Lawful Development Certificate for a Proposed Use or Development

Development: Lawful development certificate for a proposed new detached outbuilding
Location: Southdown Nursery, The Bungalow Old Mead Road Littlehampton BN17 7PU

Block Plan

BLOCK PLAN 1:500

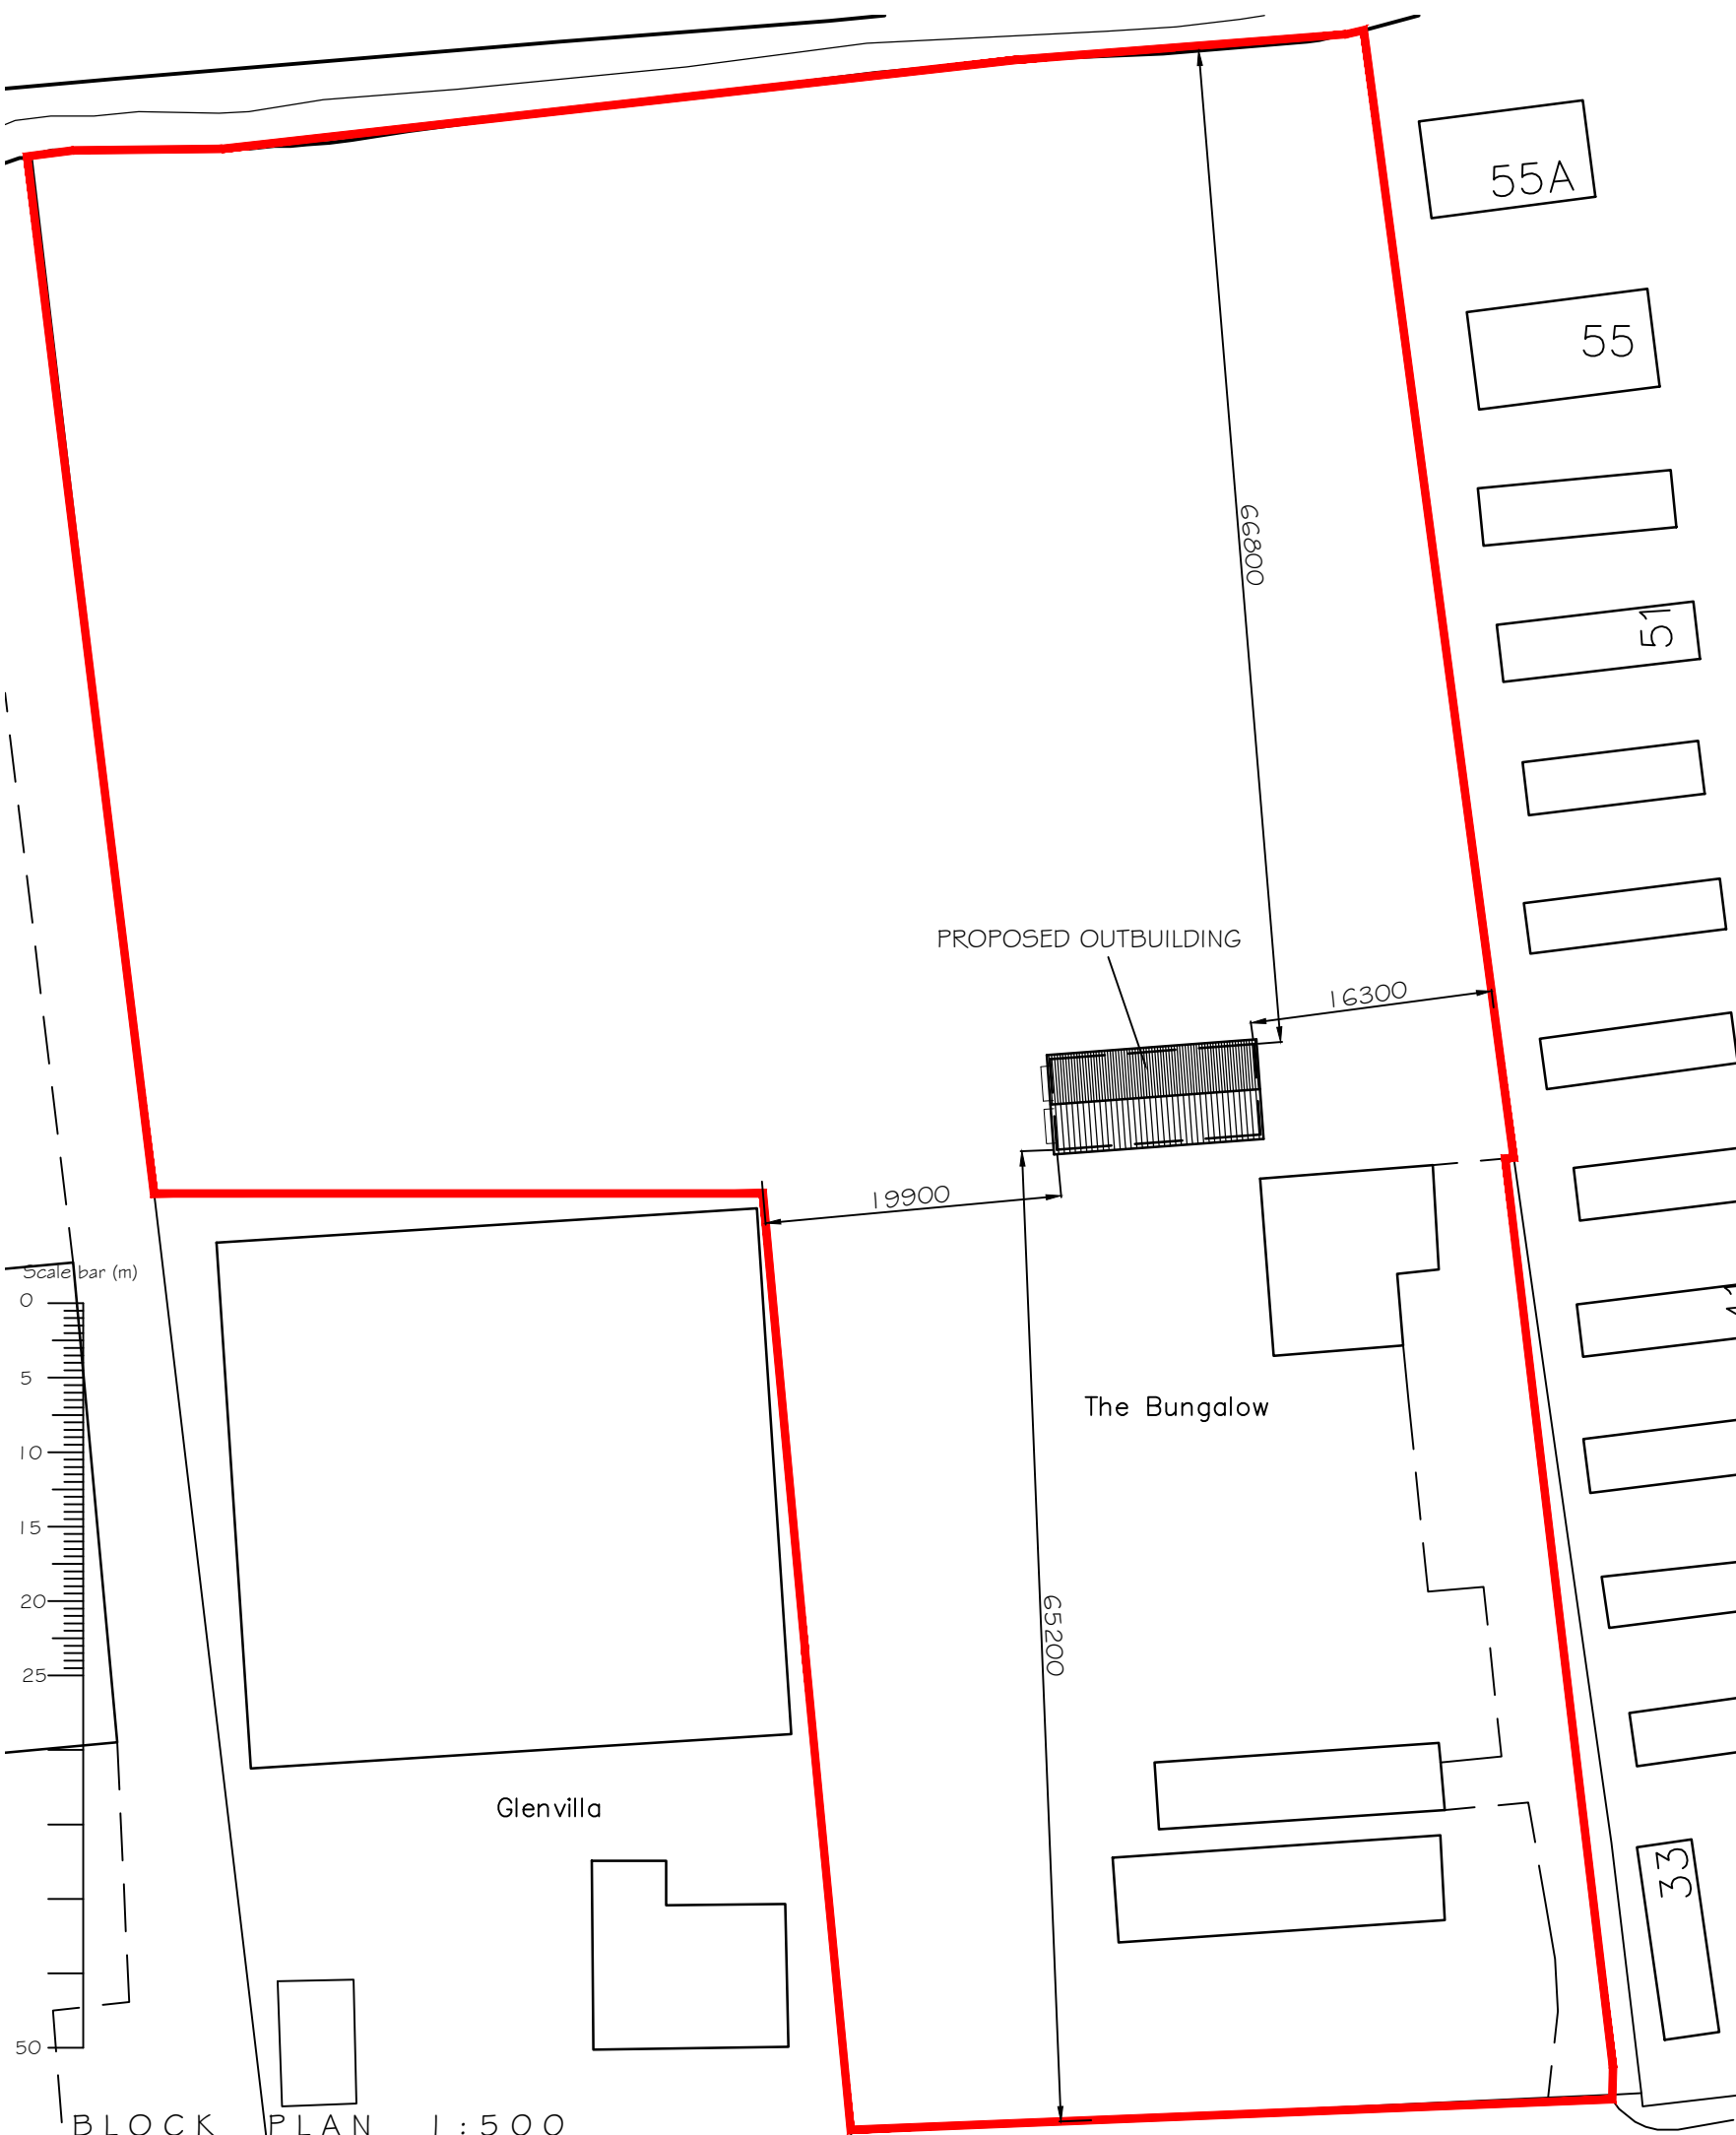
The Block Plan should include distances to boundaries from the proposed development. Please amend accordingly and re submit. Further details of what must be included on the plan can be found in the Validation Requirements List.
